16 middle St.

We currently have an application on a tenant fit up permit for Maine Media on the 5th floor. Laurie, who I know is moving into another position, says we have to comply with

A1.1

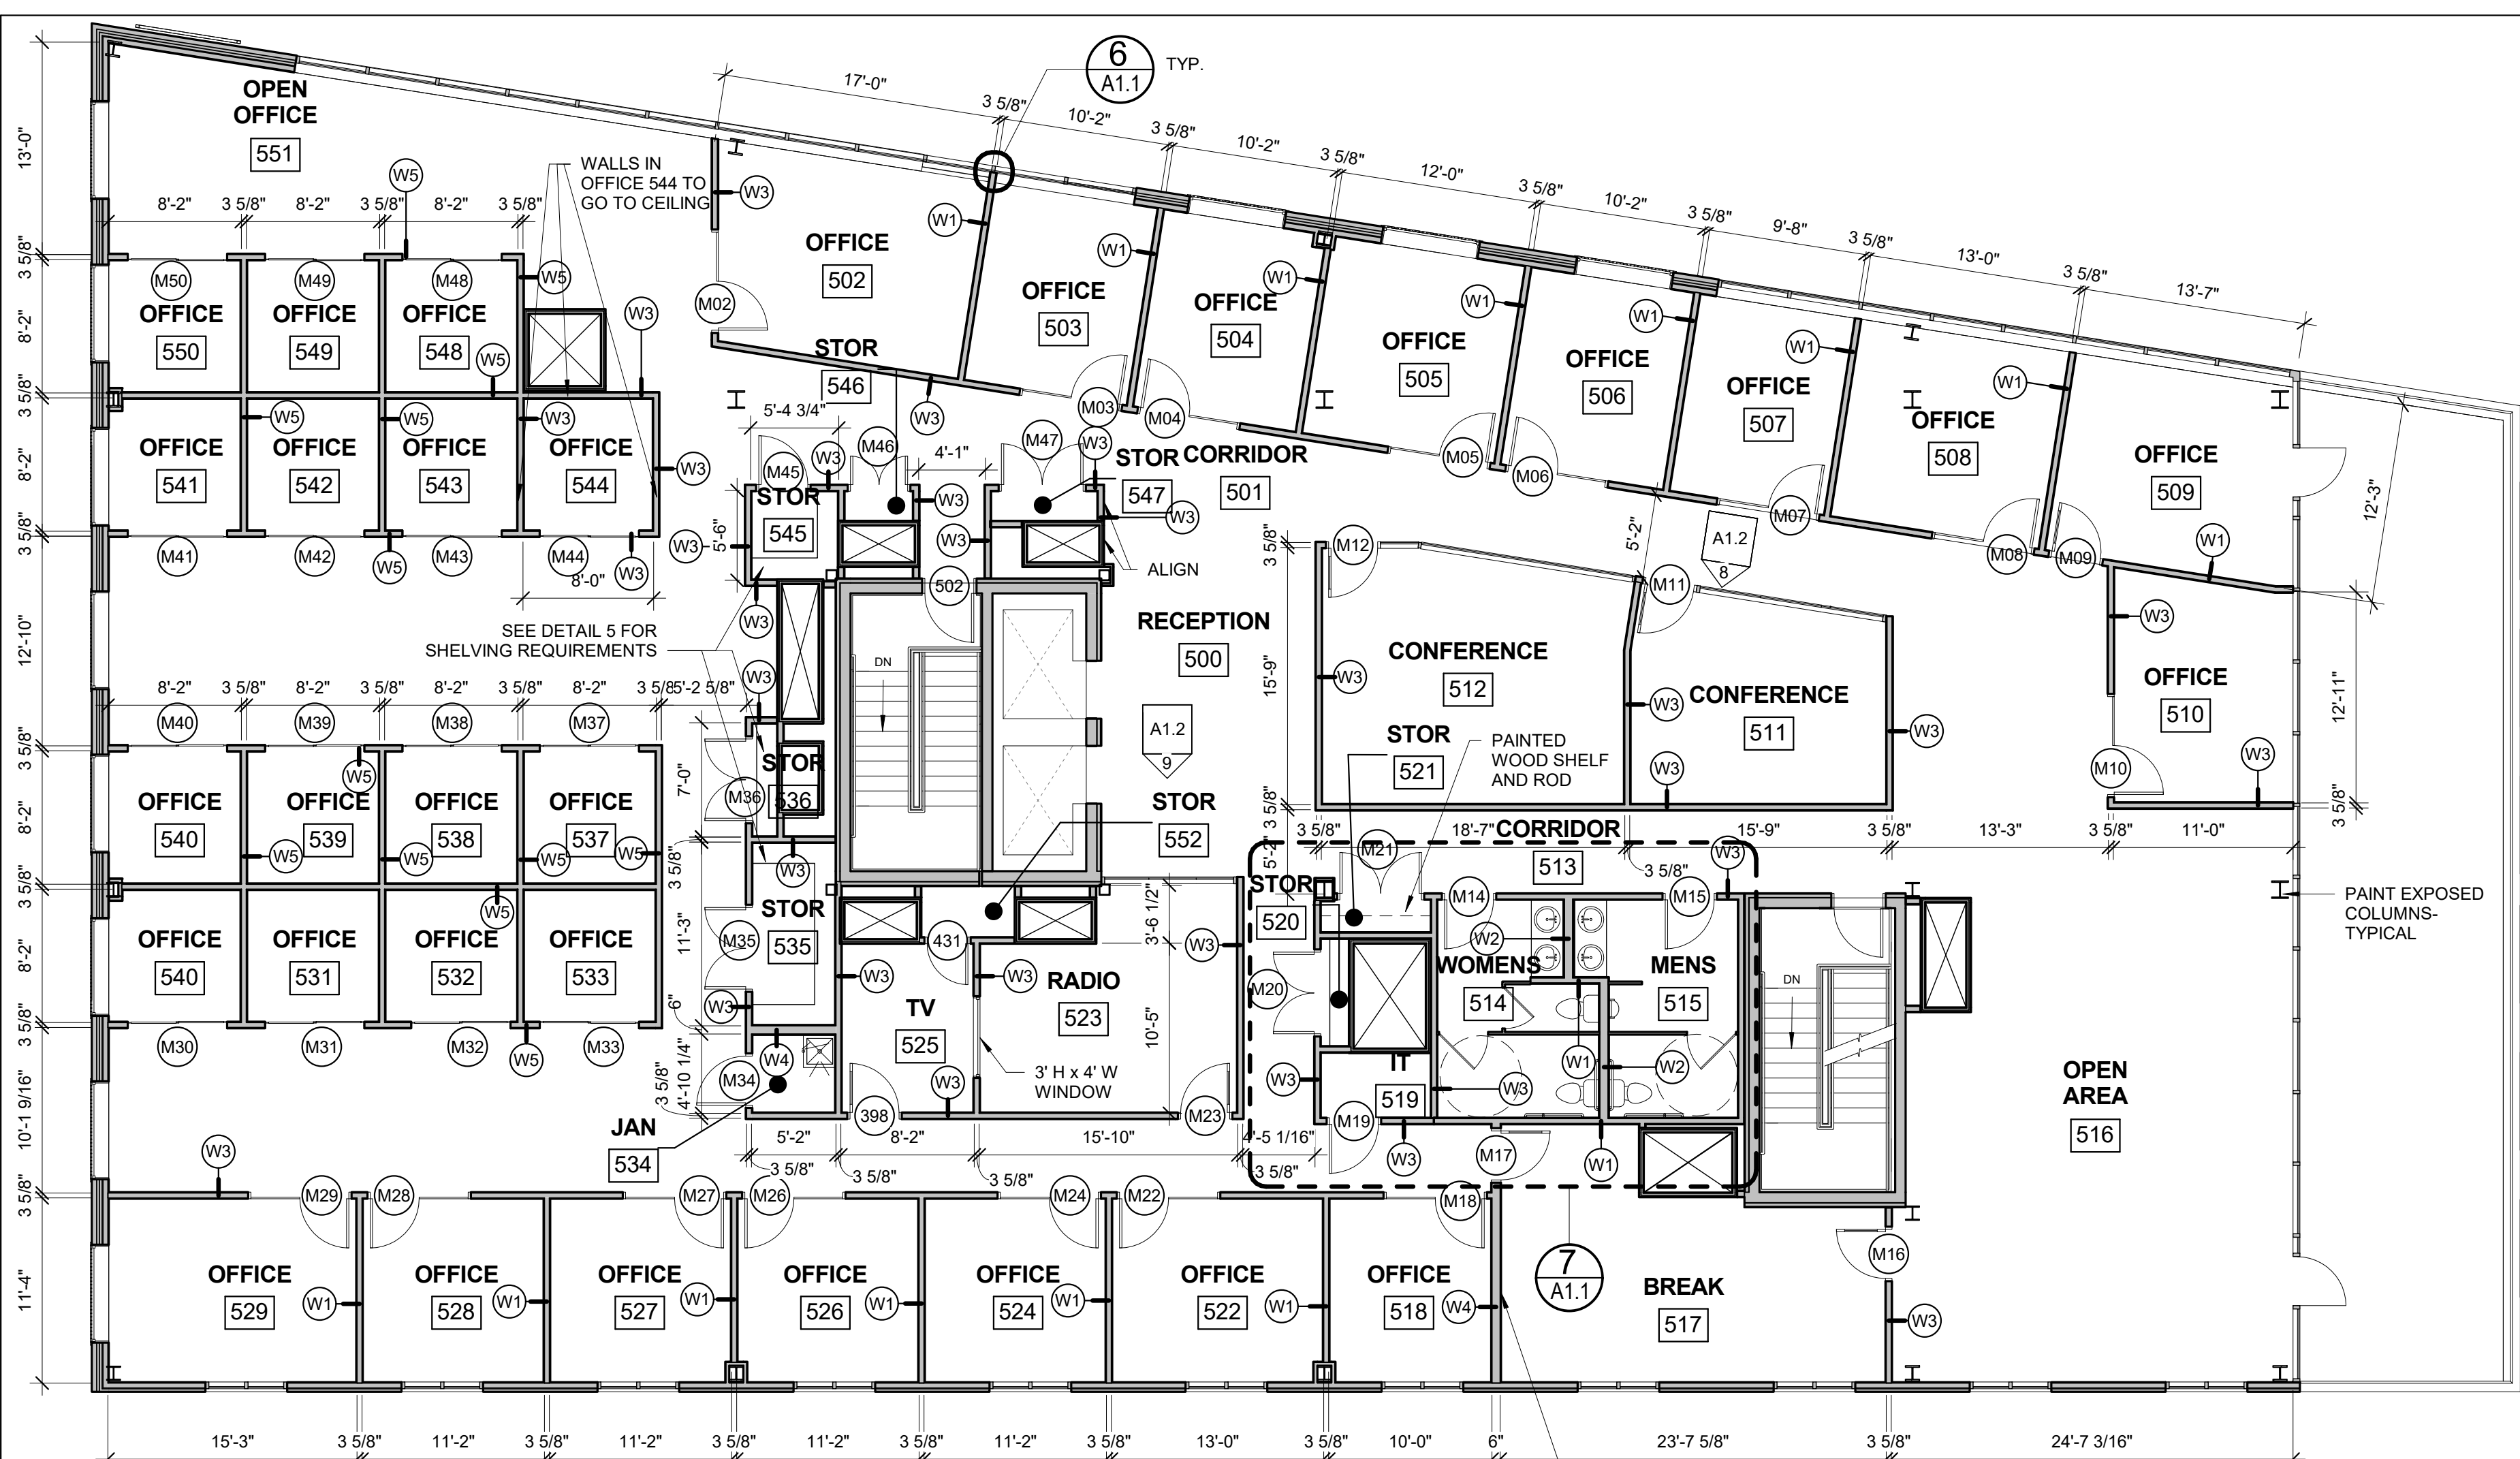
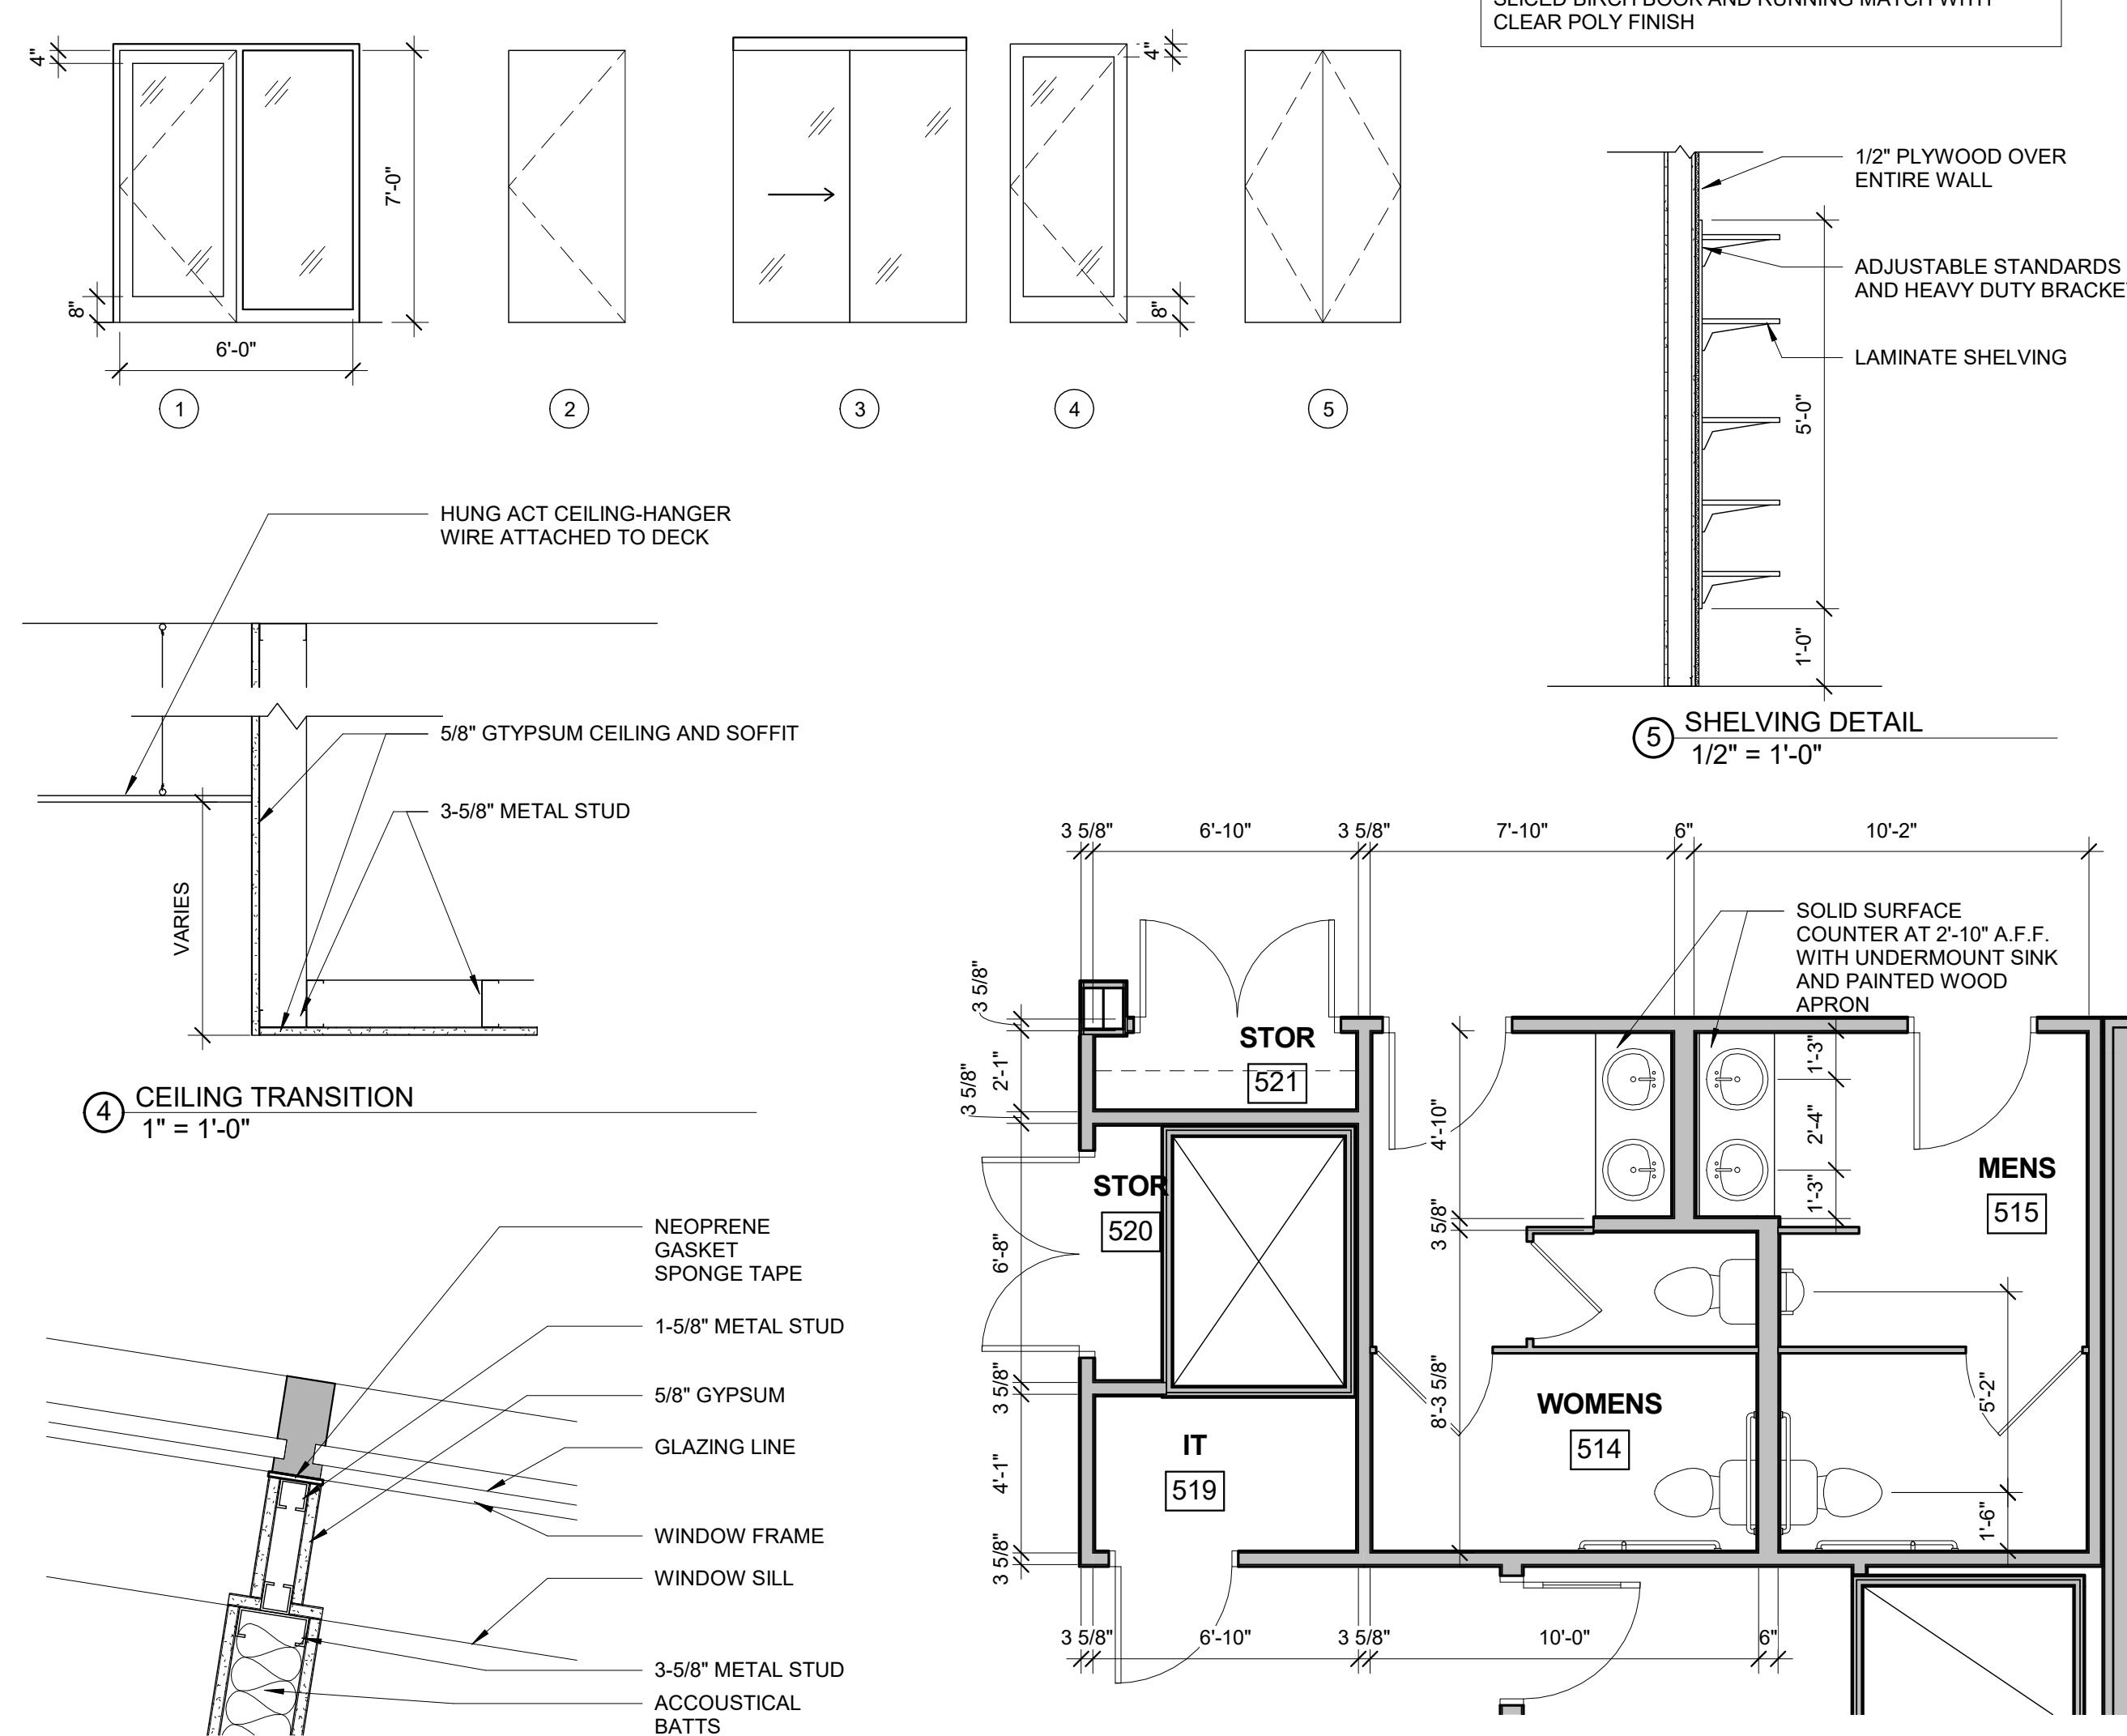
1. Table 422.1 of the UPC for a calculated gross occupant load of 107 requires 2 WC and 1 Urinal for males and 4 WC for females. As these counts are for the 51-100 range for the occupant range of each gender (200 total), it is reasonable to move down a level to 1-50 (M) and 31-50 (W) to reflect the 107. Your design would then meet the fixture count for males, but not for females (3 WC). The solution is to meet the UPC and add another WC for females.

2. As an alternative, you can provide an assessment of the actual design occupant load for the tenant space. This needs to be substantiated with documentation from the business owner noting projected levels for staff and public based on the business model. Further, the design review can support this by indicating the actual vs. the calculated occupants per the layout and use of space. We will then assess this information in order to provide a ruling.

Would it be feasible to take our actual occupant load based off of offices in this fit up. That would give us 31 total occupants, which is 15.5 per. This would allow us to be in the first tier: 1-15 which requires 1 fixture for men and 1 fixture for women. This would allow us to ‘technically’ meet UPC. We would be still providing two fixtures for both and we would still be meeting IBC for a max occupant load of 107 people.

Thank you for contacting me with this information. Based on the proposed layout of the space, which presumably corresponds with the intended tenant occupancy load of Maine Media, the proposed bathroom fixture count is deemed acceptable.

Please provide this analysis for the final approval.
